An  
Bord  
Pleanála

**Board Direction**  
**BD-005293-20**  
**ABP-305905-19**

The Board decided to refuse permission, generally in accordance with the Inspector's recommendation, for the following reasons and considerations.

BOUNDARY TREATMENTS

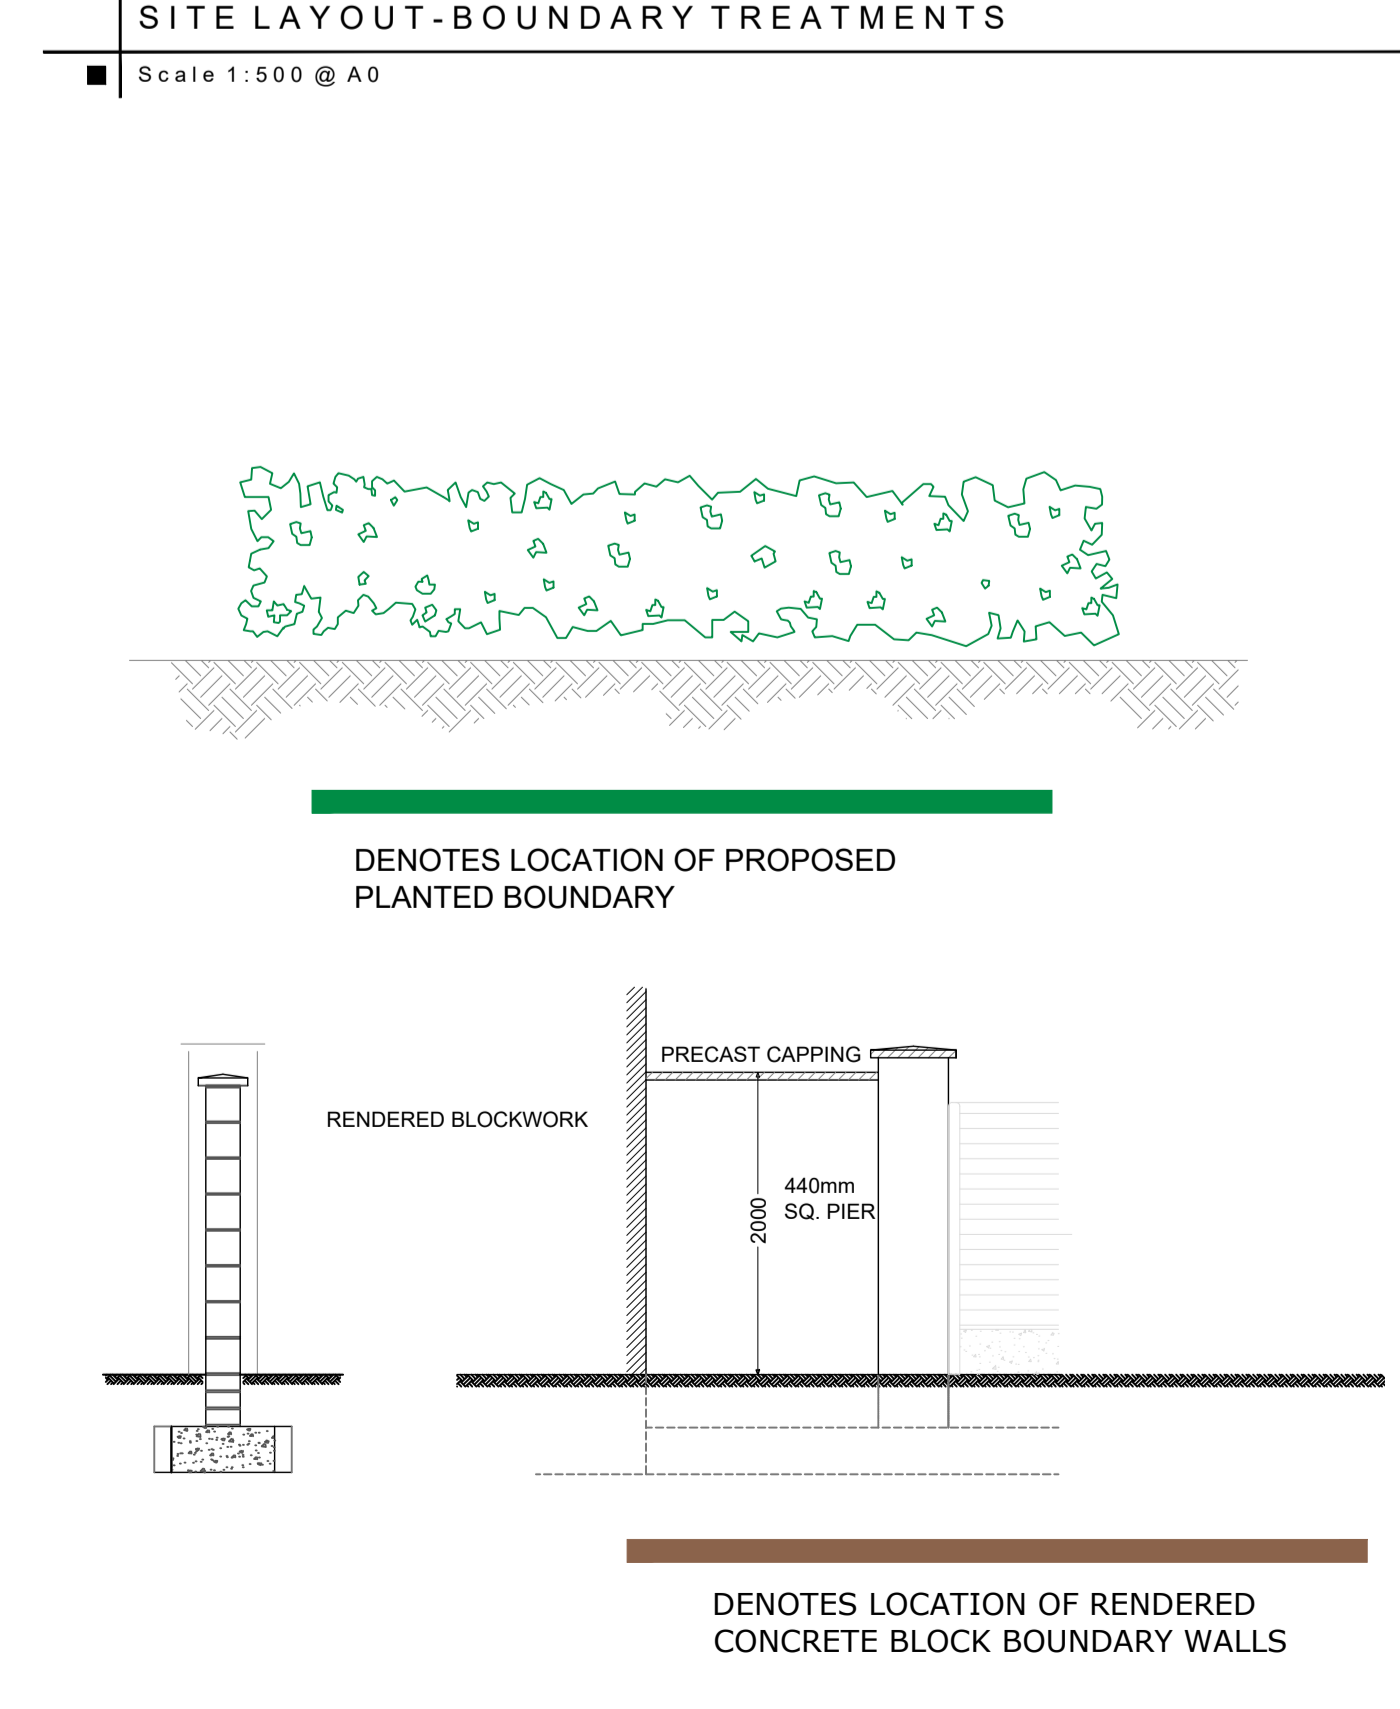
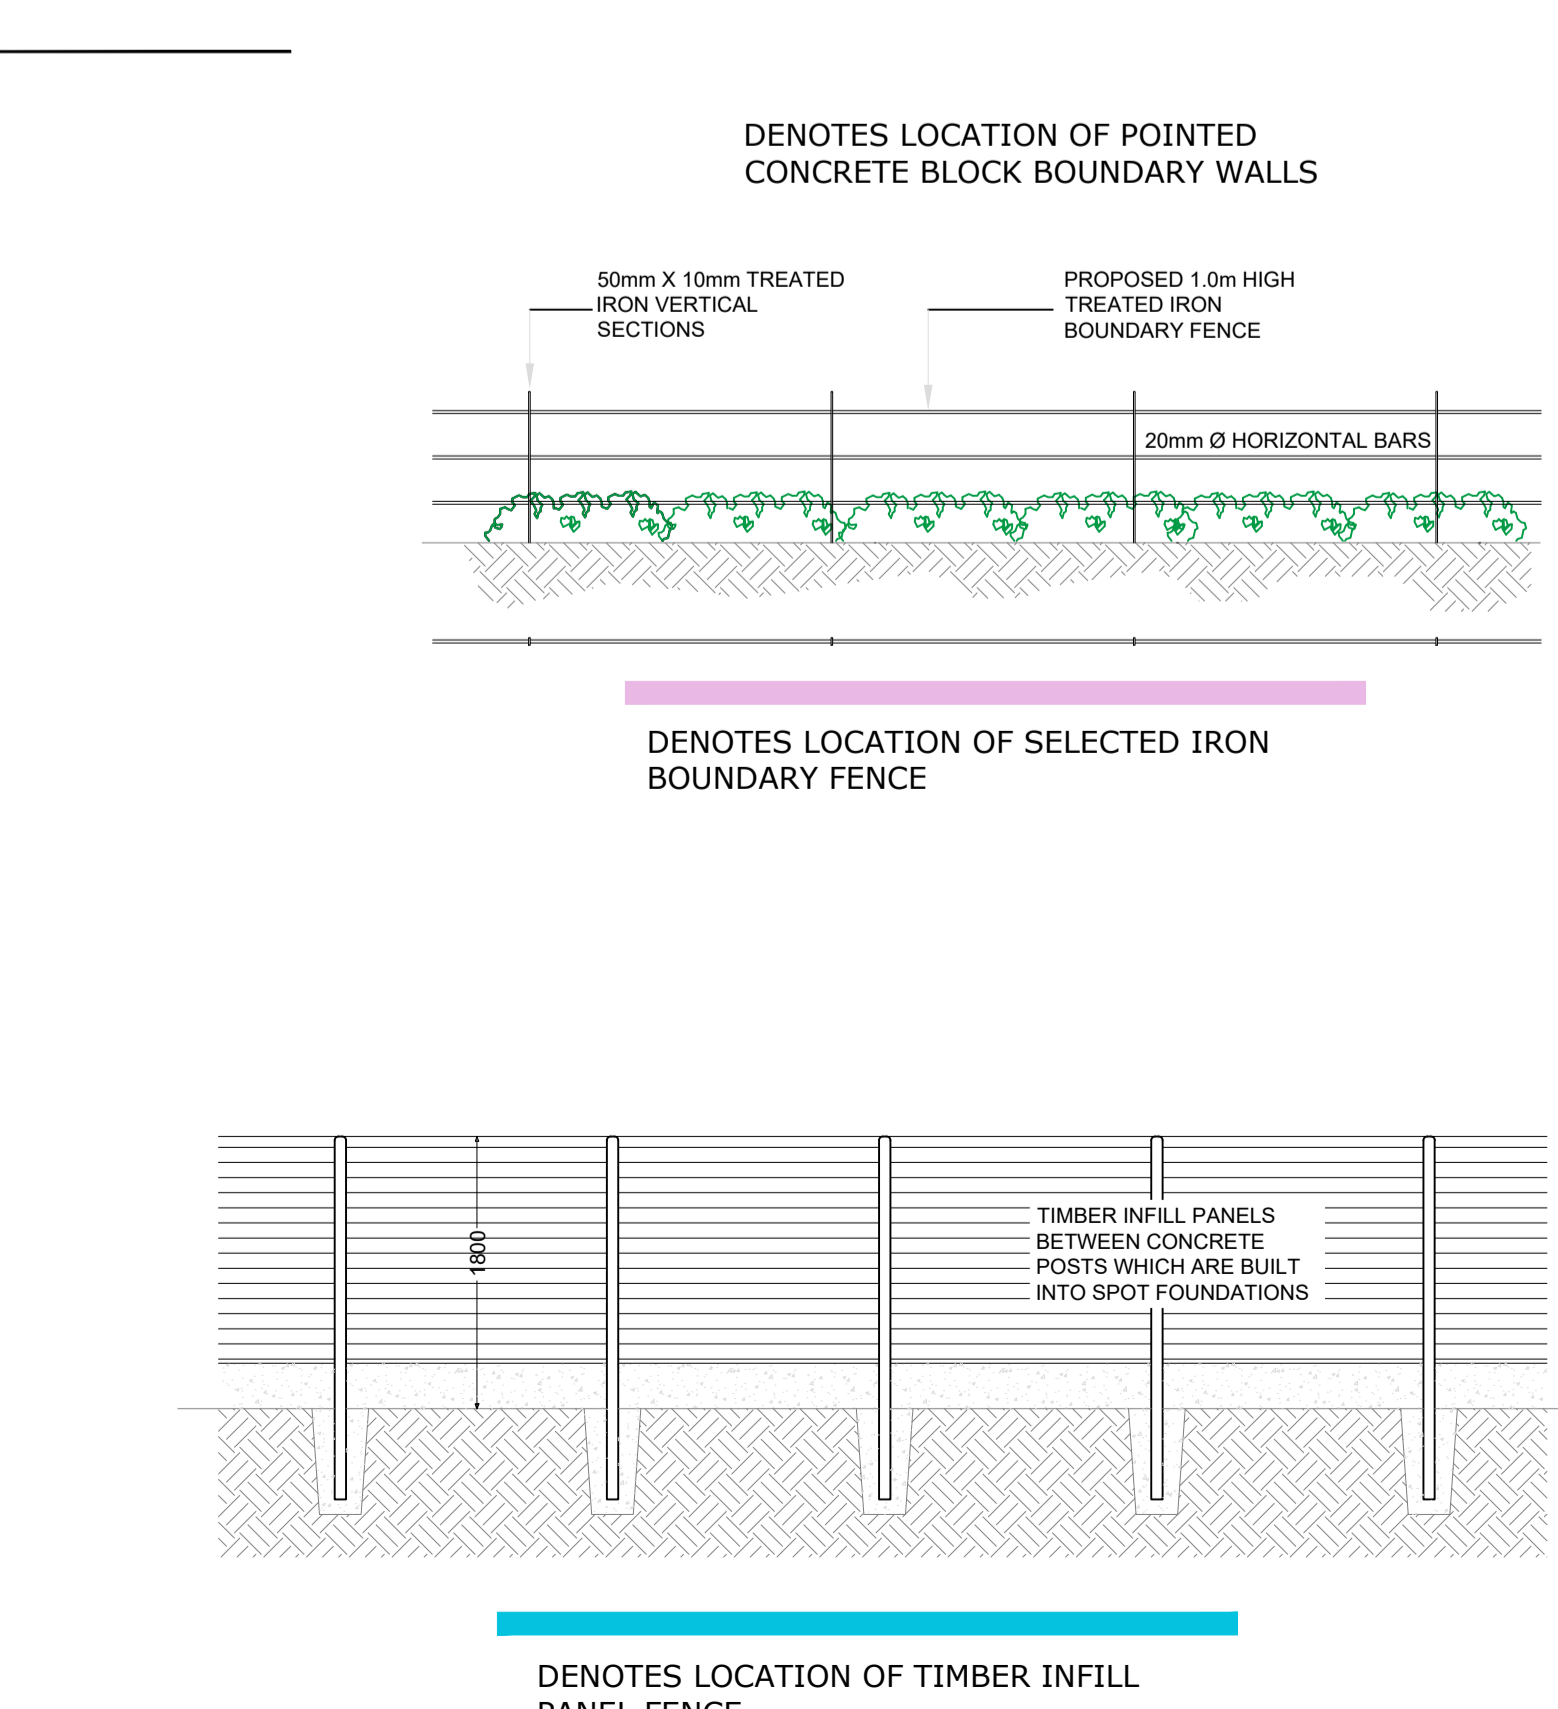
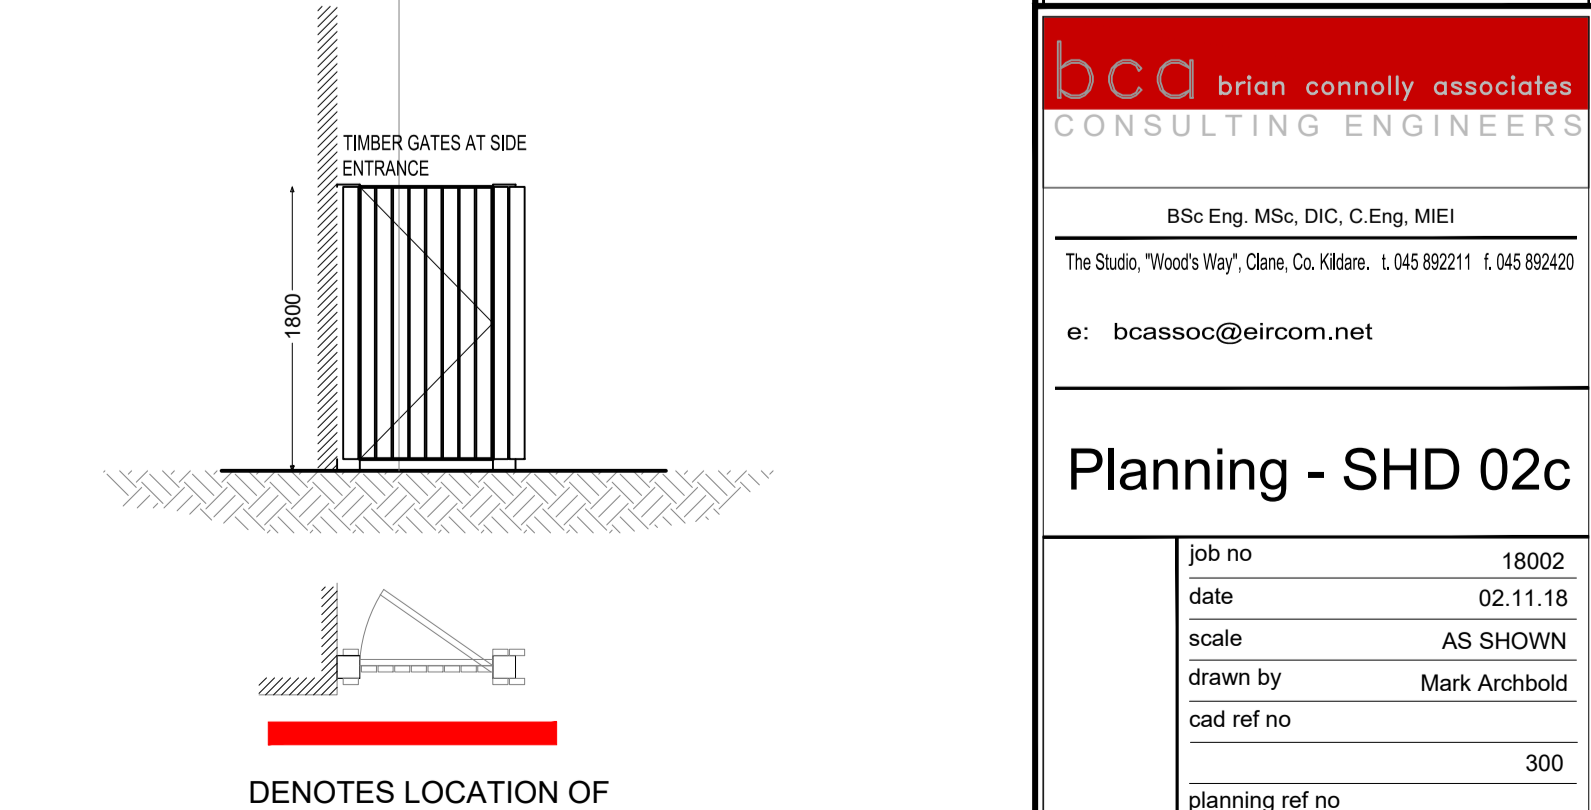
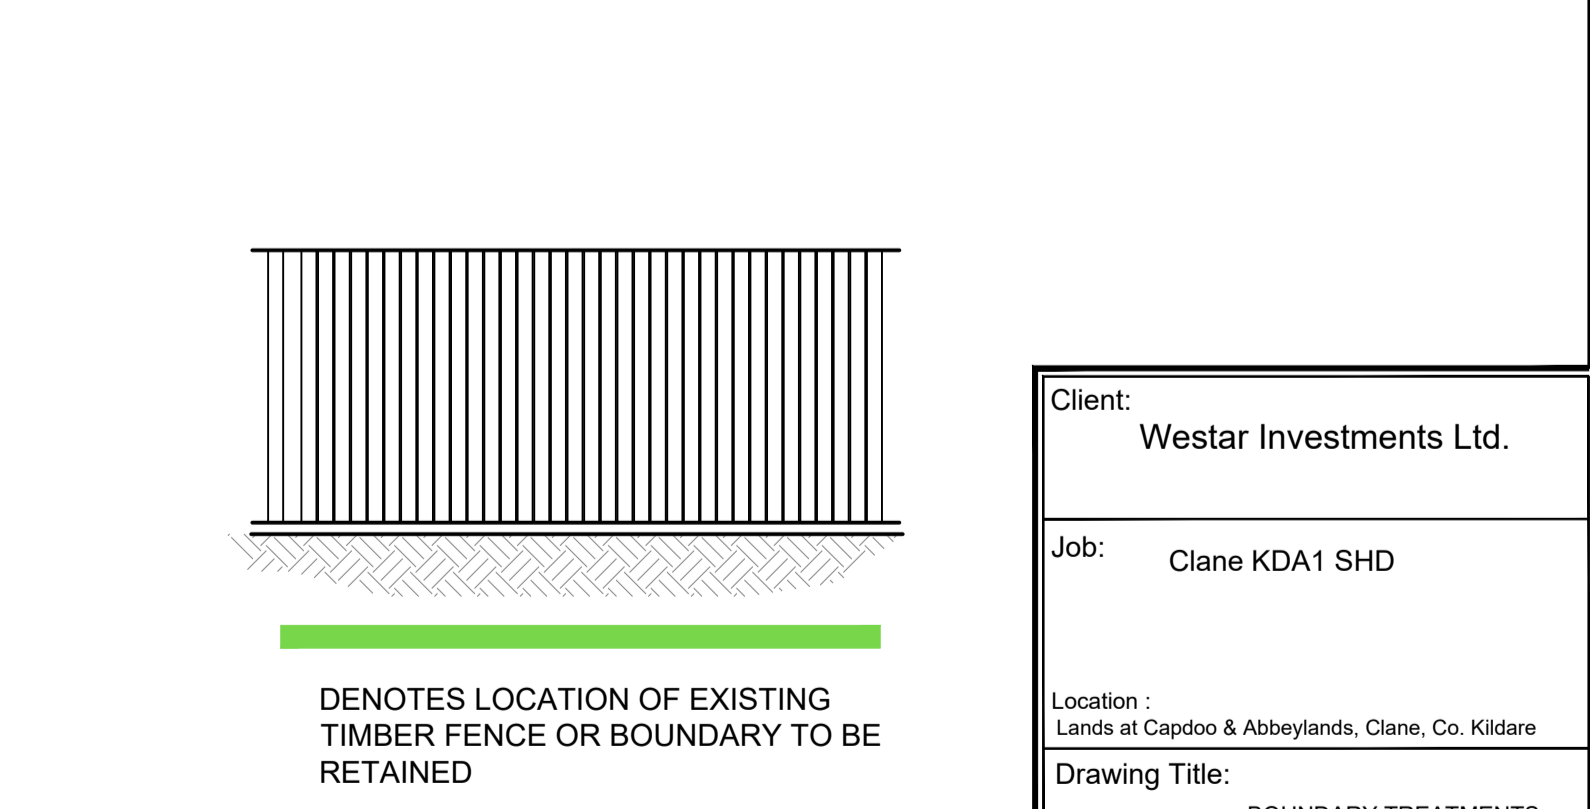
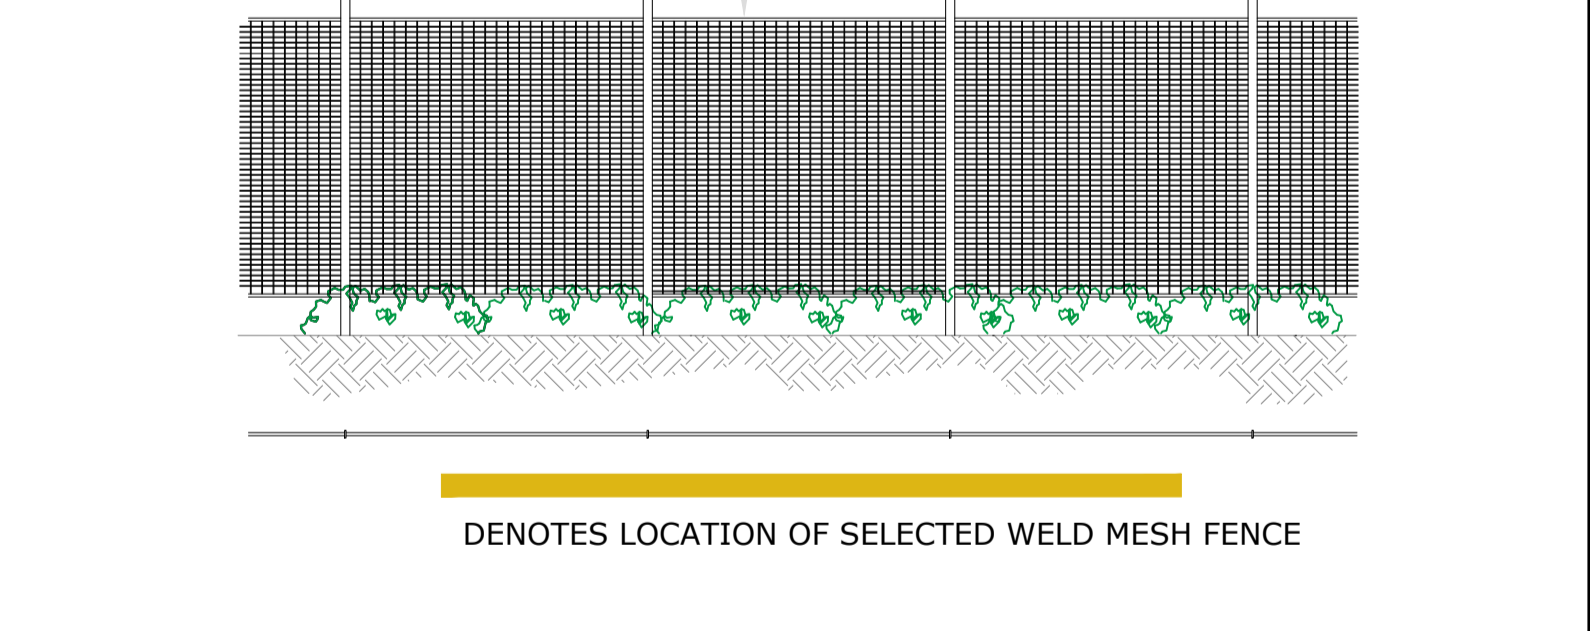
a high quality street layout that priorities people rather than vehicular movement. It is also considered that the development fails to integrate existing hedgerows satisfactorily into the layout of the development and, as such, would be contrary to objective GIO1.4 of the Clane Local Area Plan 2017-2023 which seeks to integrate hedgerows and trees into the design of new development. The proposed development would, therefore, seriously injure the residential amenities of future occupants, would be contrary to these Ministerial Guidelines and would be contrary to the proper planning and sustainable development of the area.
